**PROPOSED NORTHCONNEX M1 / M2 TUNNEL PROJECT - Application Number - SSI 13\_6136**  
**We object to many aspects of this project**

MOTORWAY OPERATIONS COMPLEX - SOUTHERN VENTILATION FACILITY - SECTIONS
M1-M2-5000-DR-JD-0525

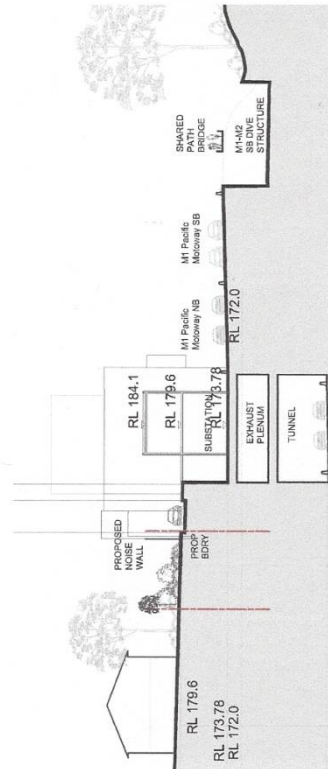
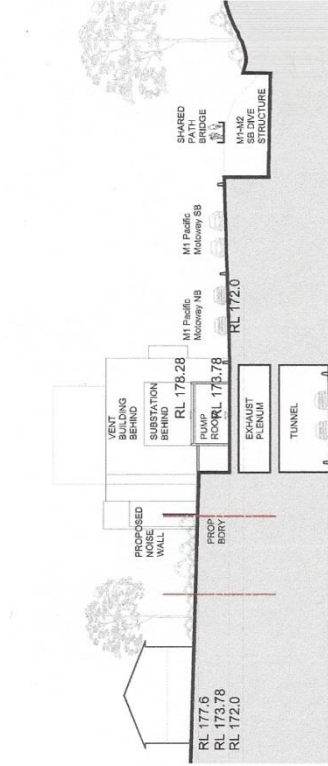
1. The Environmental Impact Statement (EIS) does not show any connection between the ventilation stack and the southbound tunnel which is 250 metres away. Will the polluted air be allowed to flow like an invisible sewer through West Pennant Hills, North Rocks, Carlingford and Beecroft?

**ACTION:** Provision of diagrams and detailed description of what ventilation is proposed for the southbound tunnel at the Southern Interchange. We would like the opportunity to lodge further submissions once that has been provided.
